**Re:** Sigma Chi Parking Lot  
**1835 Lomas Blvd NE**  
**Traffic Circulation Layout**  
Engineer's Stamp dated 12-06-16 (J15D098)

# CITY OF ALBUQUERQUE

Re: Sigma Chi Parking Lot  
1835 Lomas Blvd NE  
Traffic Circulation Layout  
Engineer's Stamp 08-02-16 (J15D098)

**RE: Sigma Chi Parking Lot  
Grading and Drainage Plan  
Engineer's Stamp Date – 8-2-2016  
Hydrology File: J15D098**

ENGINEER'S SEAL  8/2/16 DAVID SOULE P.E. #14522	NORTH 70' OF LOT 7, 8, 9, BLOCK 4 SIGMA CHI ADDITION	DRAWN BY JDG
	GRADING AND DRAINAGE PLAN	DATE 07-19-2016
 Rio Grande Engineering 1606 CENTRAL AVENUE SE SUITE 201 ALBUQUERQUE, NM 87106 (505) 872-0999	SHEET # 1 OF 1	JOB #

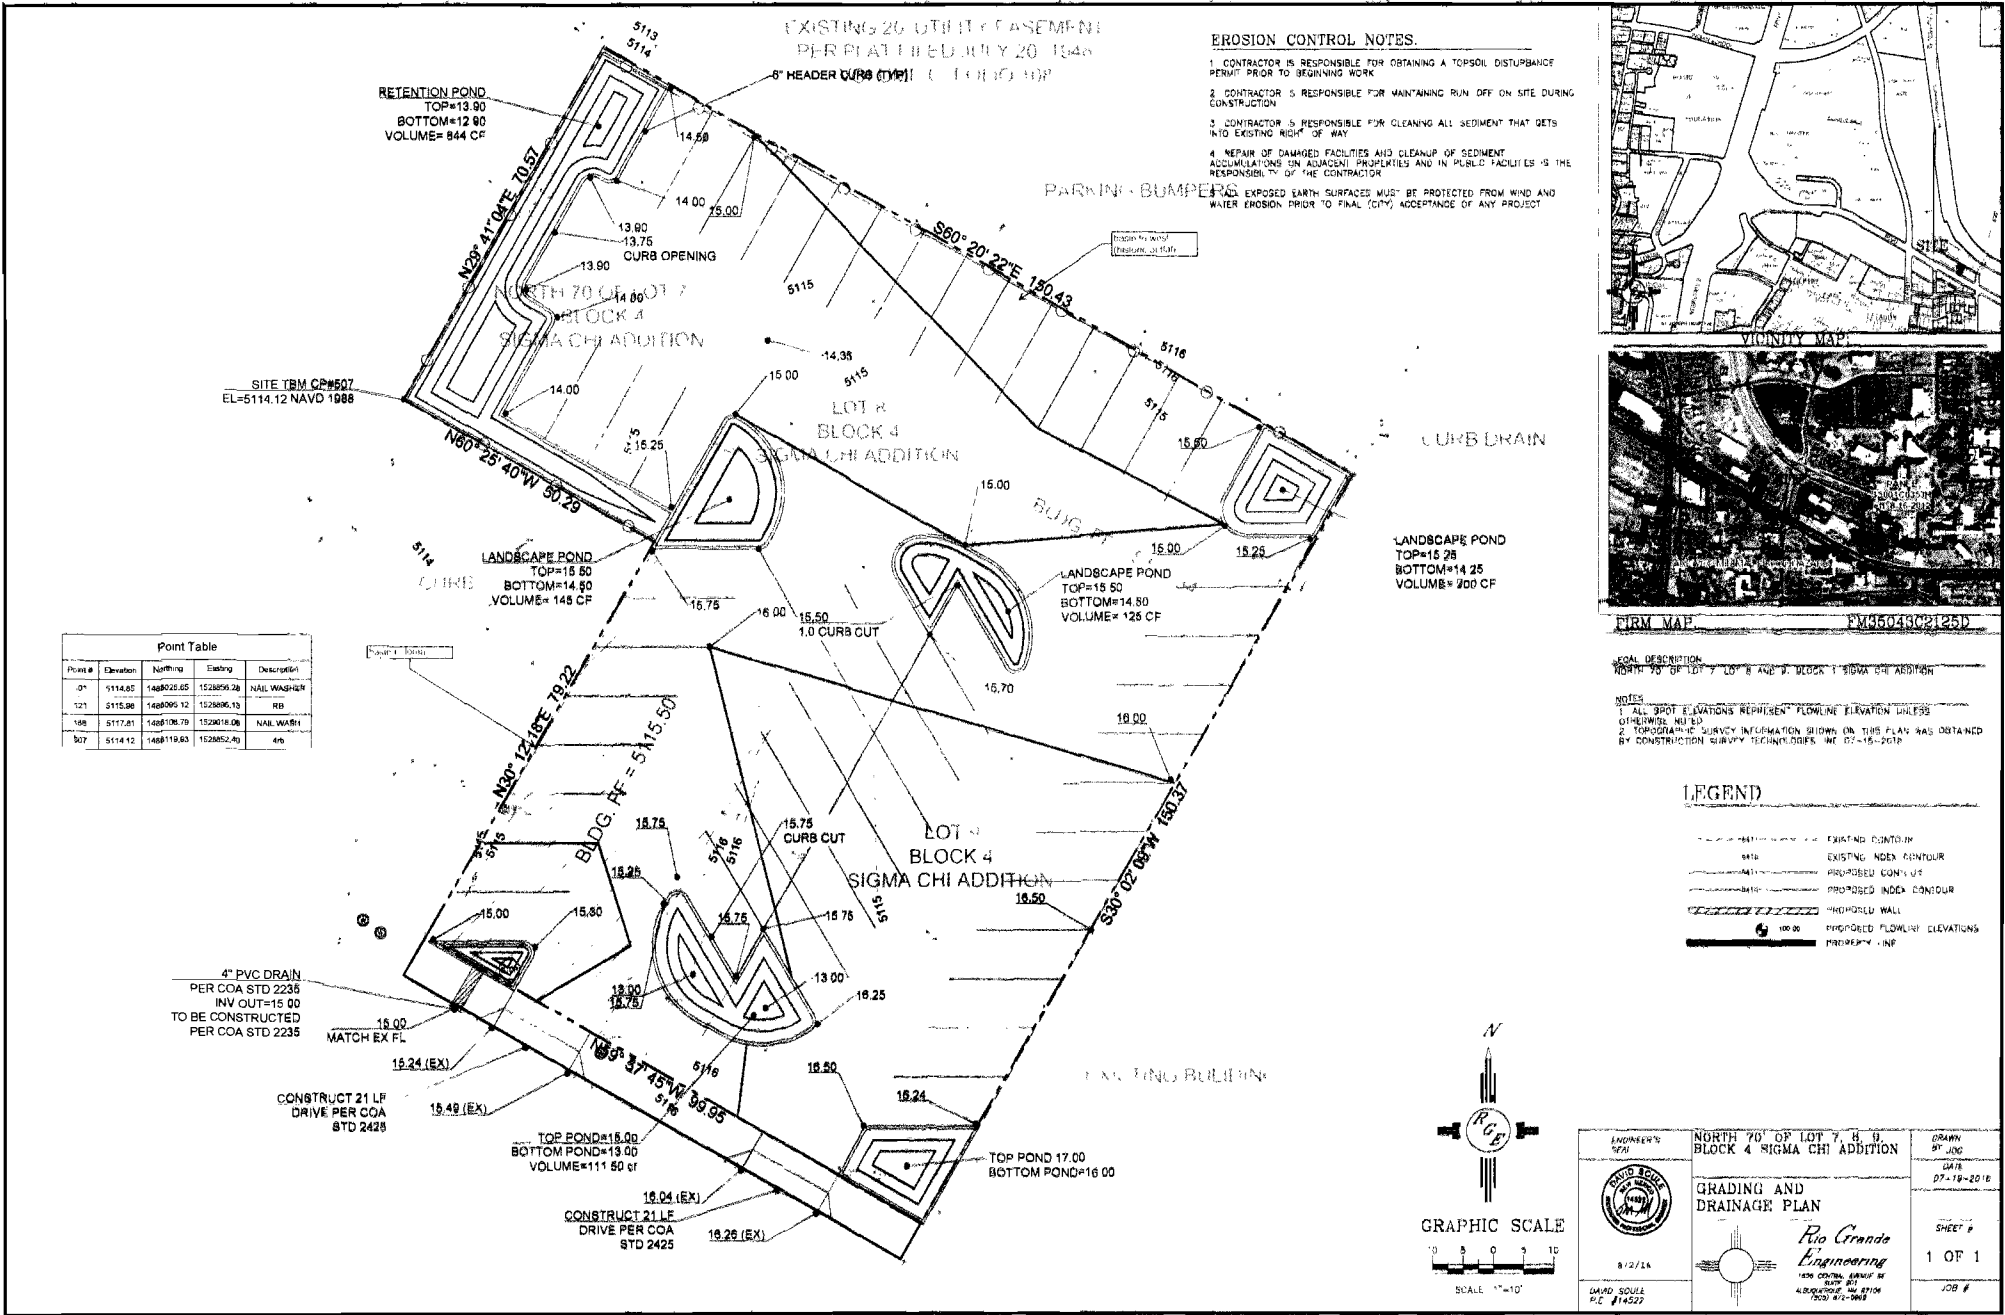
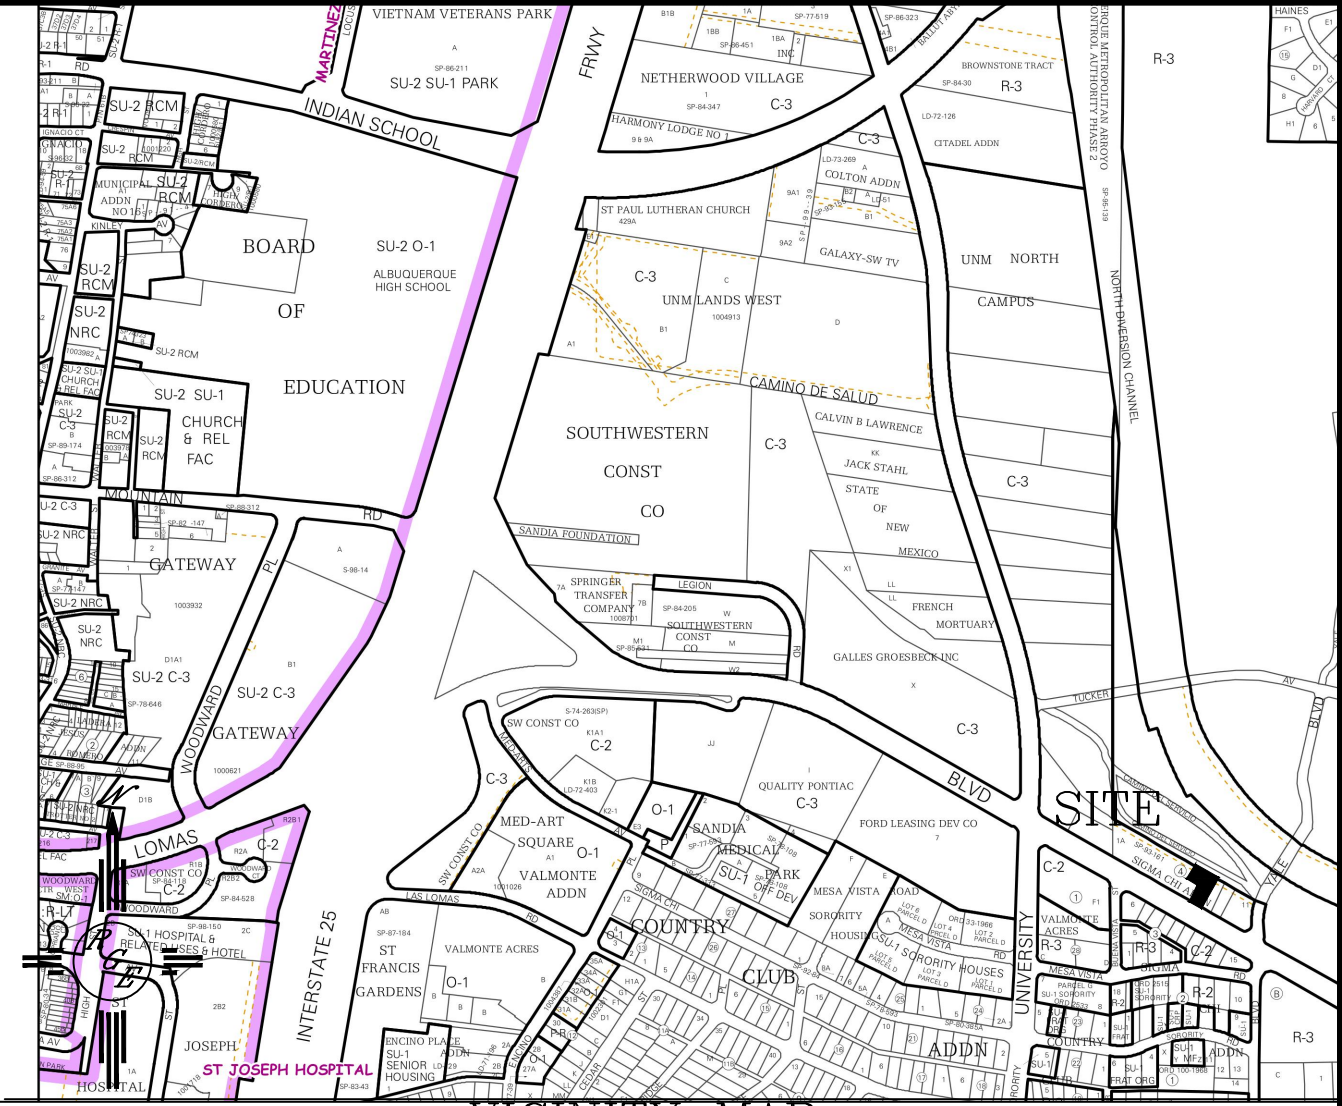
1. Remove the 4" pvc drain that is proposed through the sidewalk, which would require an SO-19 Permit. Instead, a curb cut outlet facing the driveway can provide a spillway for the adjacent pond.
2. Ensure that curb cuts are constructed on all the islands at logical low spots; some are not shown on the plan.

ENGINEER'S SEAL  DAVID SOULE P.E. #14522	NORTH 70' OF LOT 7, 8, 9, BLOCK 4 SIGMA CHI ADDITION	DRAWN BY JDG
	TRAFFIC CONTROL LAYOUT	DATE 11-18-2016
 Rio Grande Engineering 1606 CENTRAL AVENUE SE SUITE 201 ALBUQUERQUE, NM 87106 (505) 872-0999		SHEET # 1 OF 1
		JOB #

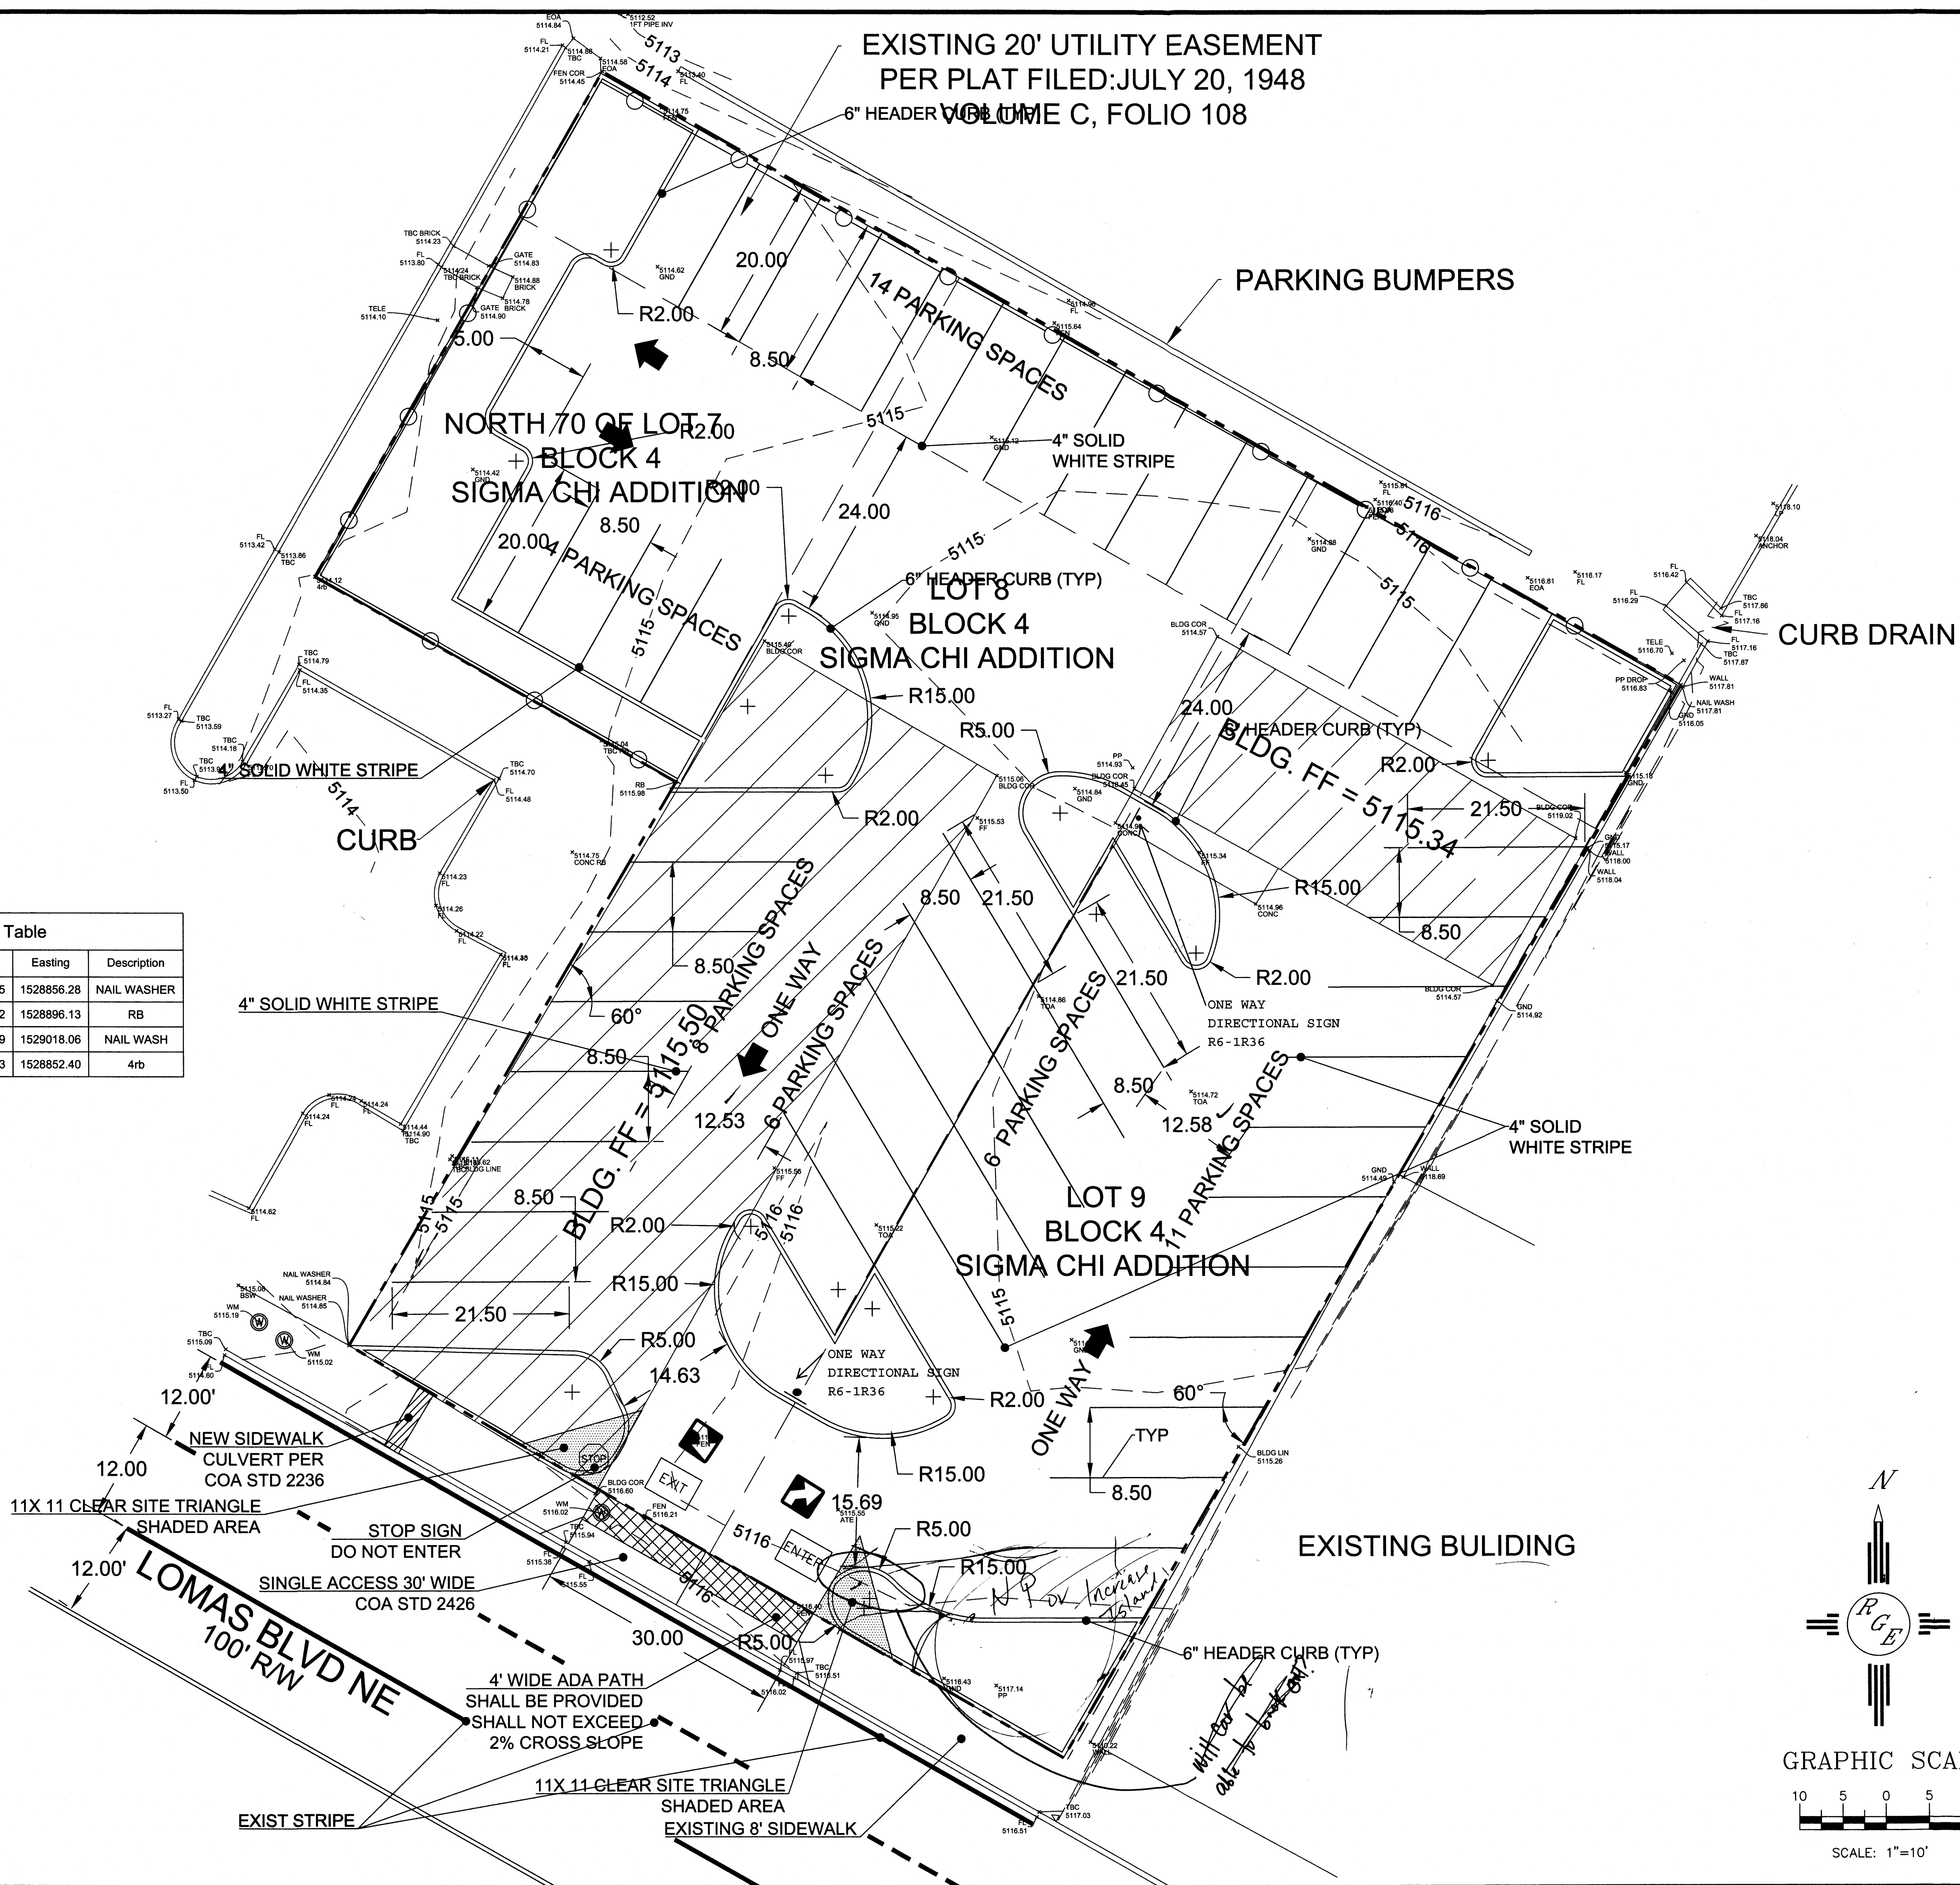
1. Please review and revise plan to provide all information listed on the attached Traffic Circulation Layout Check List.
2. Please refer to the attached Accessible Parking Checklist and revise the plan accordingly.

3. List the number of parking spaces required by the zoning code as well as the proposed number of parking spaces.
4. Please identify all existing buildings, doors, structures, sidewalks, curbs, drive pads, wall and anything that influences the parking and circulation on the site.

5. Identify the right of way width, medians, curb cuts, and street widths on Lomas Blvd.
6. Please provide grades and slopes of the parking area and or the handicap accessible parking.

7. Please list the width and length for all proposed angled parking spaces. Call out the degree in which the spaces will be angled.
8. The handicap accessible spaces must be a minimum of 8.5 ft. in width.

9. The handicap accessible spaces must include an 8 ft. wide van access aisle; all other aisles should be 5 ft. in width.
10. The ADA accessible parking sign must have the required language per 66-7-352.4C NMSA 1978 **"Violators Are Subject to a Fine and/or Towing."** Please call out detail and location of HC signs.

11. The ADA access aisles shall have the words **"NO PARKING"** in capital letters, each of which shall be at least one foot high and at least two inches wide, placed at the rear of the parking space so as to be close to where an adjacent vehicle's rear tire would be placed. (66-1-4.1.B NMSA 1978)

12. A 5 ft. keyway is required for dead-end parking aisles.

13. The curb on the Southwest corner is within the COA right of way. Please correct or provide an approved easement.
14. The 6" header curb in the Northeast corner of the property with a radii of 5' will need to be reduced to 2'.

15. Please call out and dimension motorcycle parking if required.
16. Per DPM, a 6 ft. wide ADA accessible pedestrian pathway is required from the public sidewalk and the HC parking stall access aisles to the building entrances. Please clearly show this pathway and provide details.

17. One-way vehicular paths require pavement directional signage and a posted "Do Not Enter" sign at the point of egress. Please show detail and location of posted signs.

18. It is not apparent what type of pavement surface is being proposed. A hard driving surface will be required as part of this proposed project for parking area and drive aisles.

19. Please provide a sight distance exhibit (see the *Development Process Manual*, Chapter 23, Section 3, Part D.5 Intersection Sight Distance).
20. Please add the following note to the clear sight triangle: "Landscaping and signage will not interfere with clear sight requirements. Therefore, signs, walls, trees, and shrubbery between 3 and 8 feet tall (as measured from the gutter pan) will not be acceptable in this area."

21. See Chapter 23, Section 6 of the City of Albuquerque *Development Process Manual*, for appropriate drive pad widths.
22. All broken or cracked sidewalk and driveways must be replaced with sidewalk and curb & gutter. All driveways and sidewalk must meet current ADA standards. A build note must be provided referring to the appropriate City Standard drawing.

1. Please review and revise plan to provide all information listed on the attached Traffic Circulation Layout Check List. we believe we have revised to conform

2. Please refer to the attached Accessible Parking Checklist and revise the plan accordingly. we do not have any required parking spaces therefore no ada required

3. List the number of parking spaces required by the zoning code as well as the proposed number of parking spaces we have added proposed, there are none required

4. Please identify all existing buildings, doors, structures, sidewalks, curbs, drive pads wall and anything that influences the parking and circulation on the site. we have added labels

5. Identify the right of way width, medians, curb cuts, and street widths on Lomas Blvd. we have added
6. Please provide grades and slopes of the parking area and or the handicap accessible parking. no ada parking required

7. Please list the width and length for all proposed angled parking spaces. Call out the degree in which the spaces will be angled. we have added dimensions and angles

8. The handicap accessible spaces must be a minimum of 8.5 ft. in width.
9. The handicap accessible spaces must include an 8 ft. wide van access aisle; all other aisles should be 5 ft. in width. no ada parking required

10. The ADA accessible parking sign must have the required language per 66-7-352.4C NMSA 1978 **"Violators Are Subject to a Fine and/or Towing."** Please call out detail and location of HC signs. no ada parking required

11. The ADA access aisles shall have the words **"NO PARKING"** in capital letters, each of which shall be at least one foot high and at least two inches wide, placed at the rear of the parking space so as to be close to where an adjacent vehicle's rear tire would be placed. (66-1-4.1.B NMSA 1978) no ada parking required

12. A 5 ft. keyway is required for dead-end parking aisles. we have added

13. The curb on the Southwest corner is within the COA right of way. Please correct or provide an approved easement. we have adjusted
14. The 6" header curb in the Northeast corner of the property with a radii of 5' will need to be reduced to 2'. we have corrected

15. Please call out and dimension motorcycle parking if required. no mc required
16. Per DPM, a 6 ft. wide ADA accessible pedestrian pathway is required from the public sidewalk and the HC parking stall access aisles to the building entrances. Please clearly show this pathway and provide details. we have no buildings

17. One-way vehicular paths require pavement directional signage and a posted "Do Not Enter" sign at the point of egress. Please show detail and location of posted signs. we had added locations and referenced sign model numbers

18. It is not apparent what type of pavement surface is being proposed. A hard driving surface will be required as part of this proposed project for parking area and drive aisles. we have added note regarding paving

19. Please provide a sight distance exhibit (see the *Development Process Manual, Chapter 23, Section 3, Part D.5 Intersection Sight Distance*). added clear site

20. Please add the following note to the clear sight triangle: "Landscaping and signage will not interfere with clear sight requirements. Therefore, signs, walls, trees, and shrubbery between 3 and 8 feet tall (as measured from the gutter pan) will not be acceptable in this area." we have added call out in the notes

21. See Chapter 23, Section 6 of the *City of Albuquerque Development Process Manual*, for appropriate drive pad widths. we have added widths
22. All broken or cracked sidewalk and driveways must be replaced with sidewalk and curb & gutter. All driveways and sidewalk must meet current ADA standards. A build note must be provided referring to the appropriate City Standard drawing. we have added call out in the notes
